VALLEY STREET
 NEW BUILDING
 1450 VALLEY STREET
 COLORADO SPRINGS, CO 80934
 EL PASO COUNTY, COLORADO

SITE PLAN

1 SITE PLAN
SCALE: 1"=20'-0"

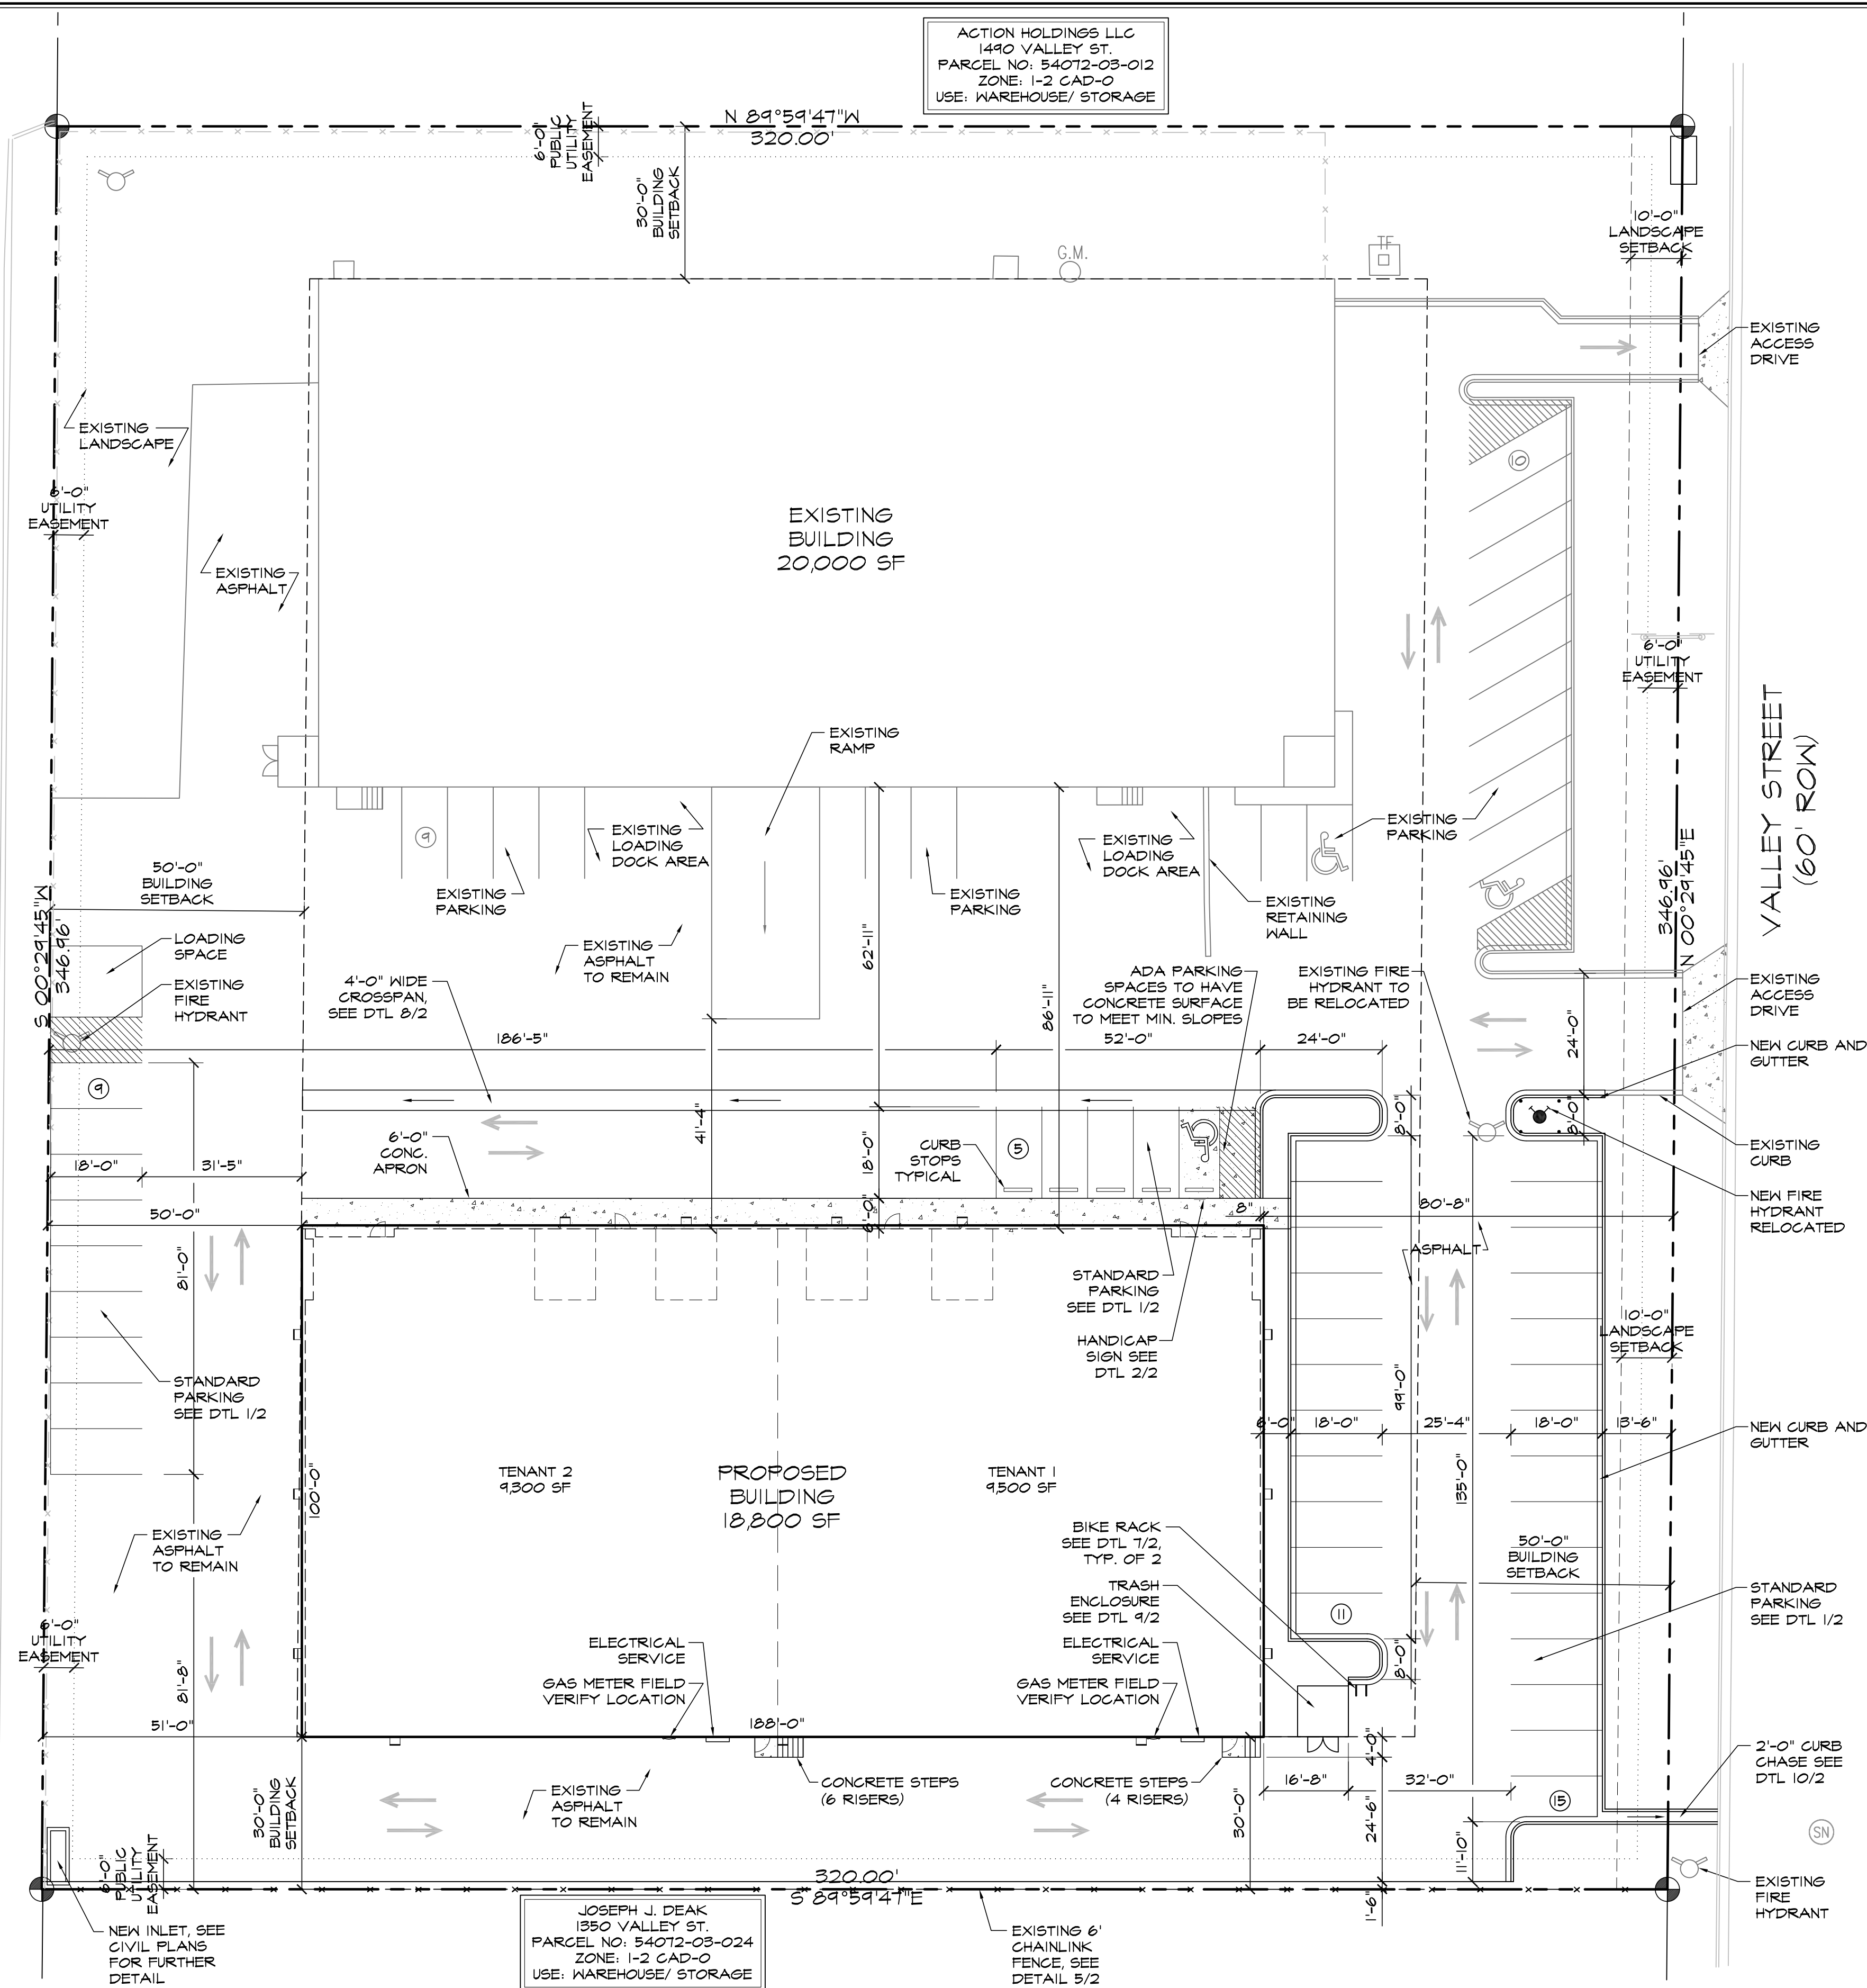
Please add the following note to the site plan:
 - The parties responsible for this plan have familiarized themselves with all current accessibility criteria and specifications and the proposed plan reflects all site elements required by the applicable ADA design standards and guidelines as published by the United States Department of Justice. Approval of this plan by El Paso County does not assure compliance with the ADA or any regulations or guidelines enacted or promulgated under or with respect to such laws.

Please include:
 -well and septic sites, if none please specify
 -location of no build areas, if none please specify
 -location of off street parking, if applicable

There is no approved driveway access permit on file for the two existing driveways. Applicant will have to apply for driveway access permits prior to building permit approval. Additionally, the maximum number of driveways allowed for the parcel is two (2). Applicant will have to close one of the existing driveways prior to construction of the proposed driveway.

Please refer to ECM 2.4.1. B and ECM table 2-35 for required distance between the proposed driveways

Please be sure to identify which driveways are new and which are existing. Also specify the appropriate EPC standard driveway detail
